**From:** [Berry, Jon](#)  
**To:** [Norfolk Boreas](#)  
**Subject:** Norfolk Boreas Wind Farm Project - Breckland Council  
**Date:** 09 December 2019 11:25:16  
**Attachments:** [Norfolk Boreas Breckland Council SoCG 04.12.2019.docx](#)  
[Norfolk Boreas Wind Farm - Local Impact Report Summary 04.12.2019.docx](#)  
[Norfolk Boreas DCO Application - Breckland Council Local Impact Report 04.12.2019.docx](#)  
[Norfolk Boreas Breckland Council Environmental Health Answers.docx](#)

Please see the attached Statement of Common Ground, the Local Impact Report and a Summary of the Local Impact Report for the Norfolk Boreas Wind Farm project. The Local Impact Report addresses the majority of the written questions put forward by the Examining Authority for Breckland Council, though I also attach a specific response from the Environmental Health team to matters relevant to those officers.

I have had a look at the questions posed and been back through the PEIR and answered anything that I think is pertinent to BDC

Title:
Norfolk Boreas study areas
(Map 6 of 9)

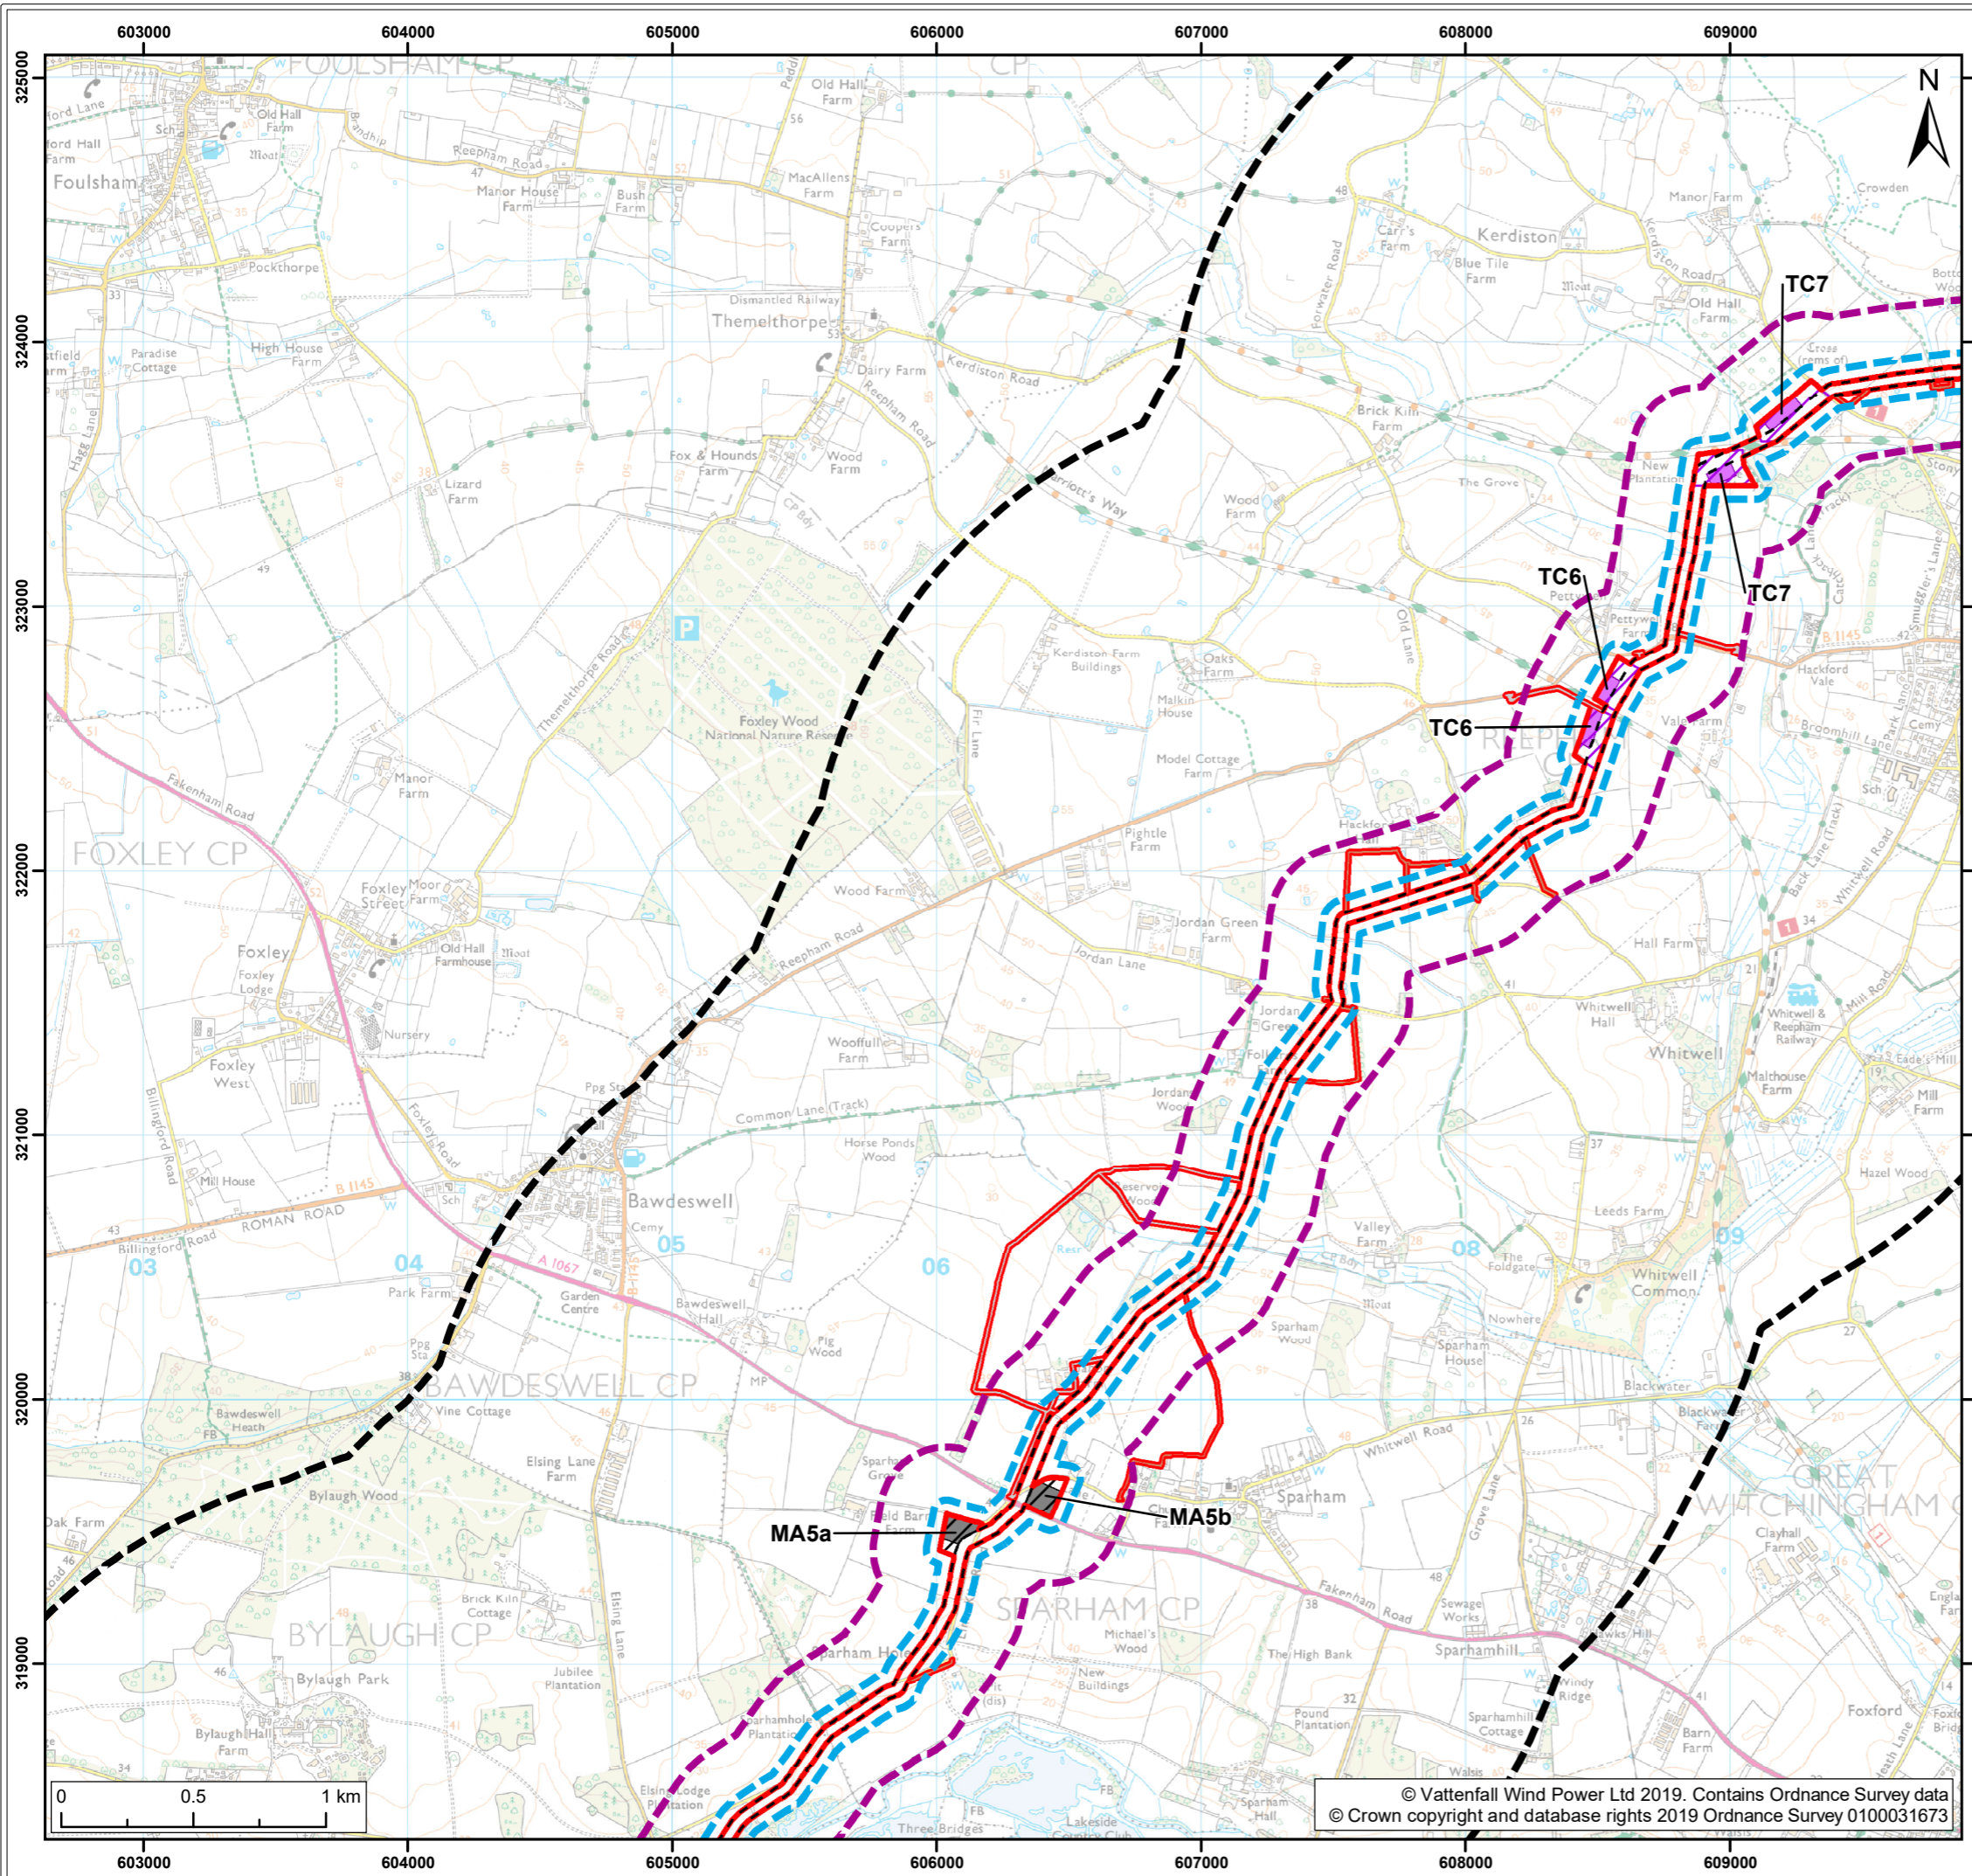
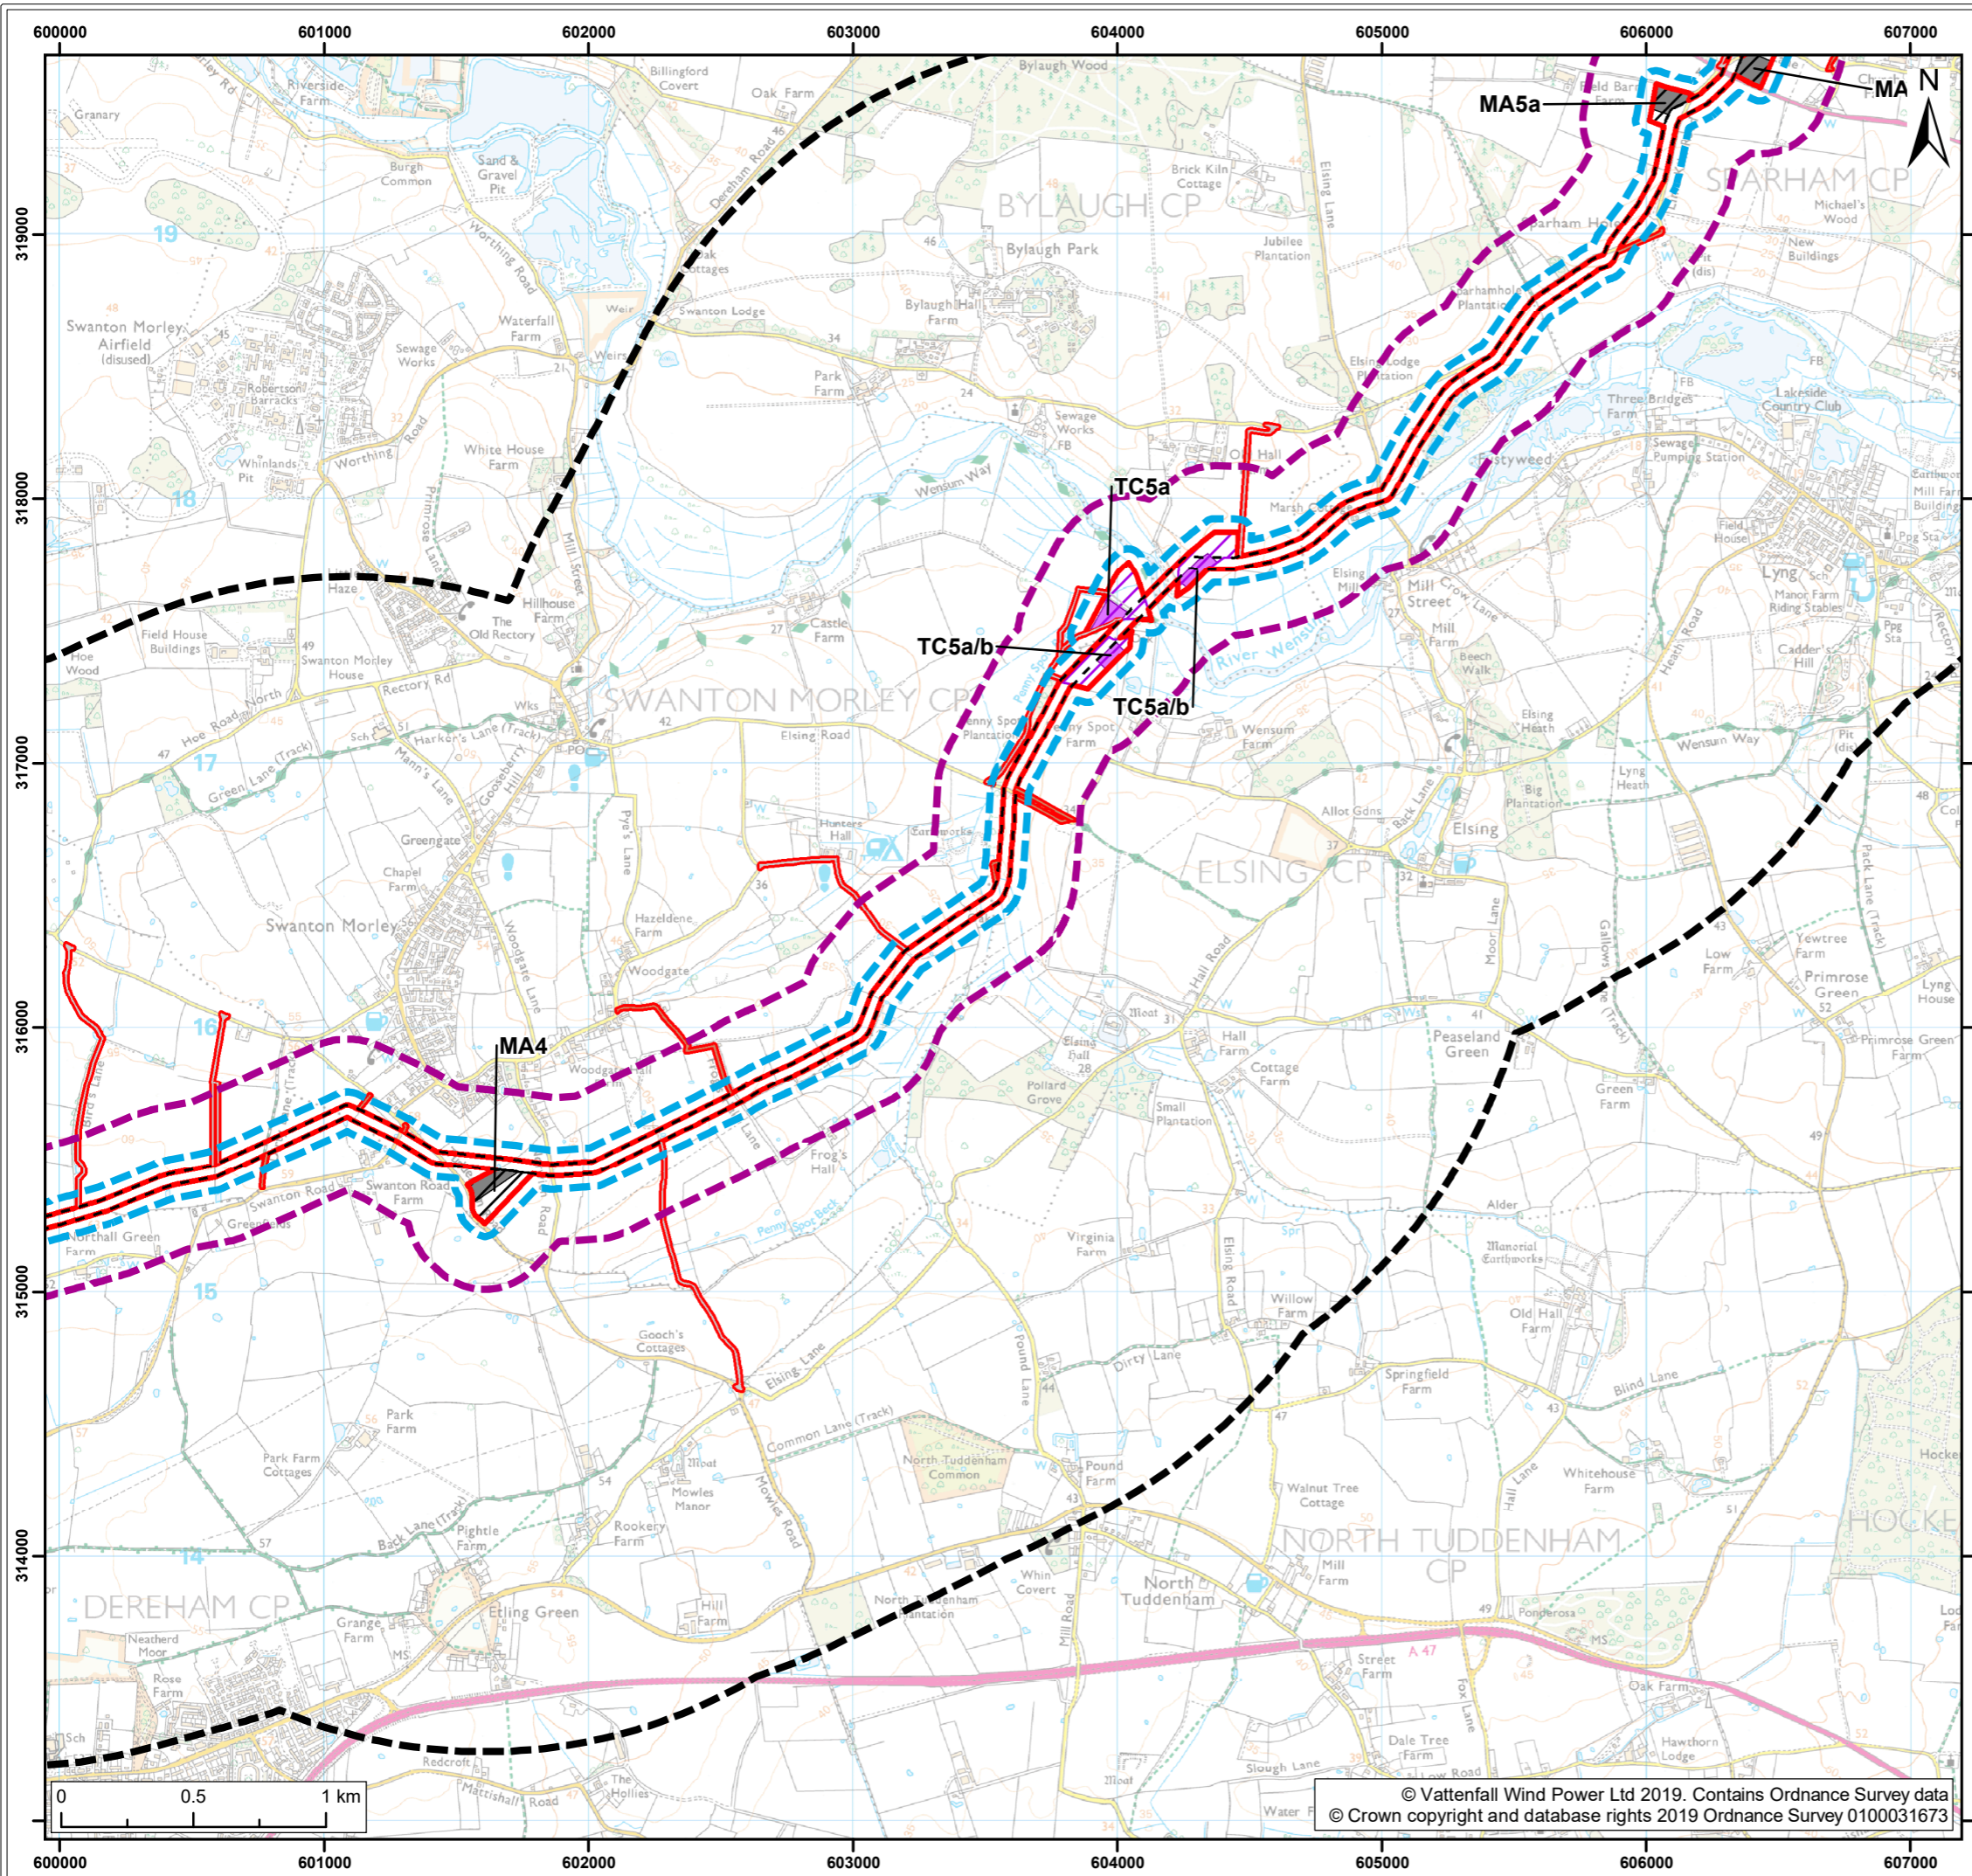
Part of map 6 and maps 7, 8 and 9 show Breckland district. For the cable route receptors CCR, there are 14, of which 6 are on the southern or south east side of the cable route. Having looked again I feel they are representative of the residential areas.
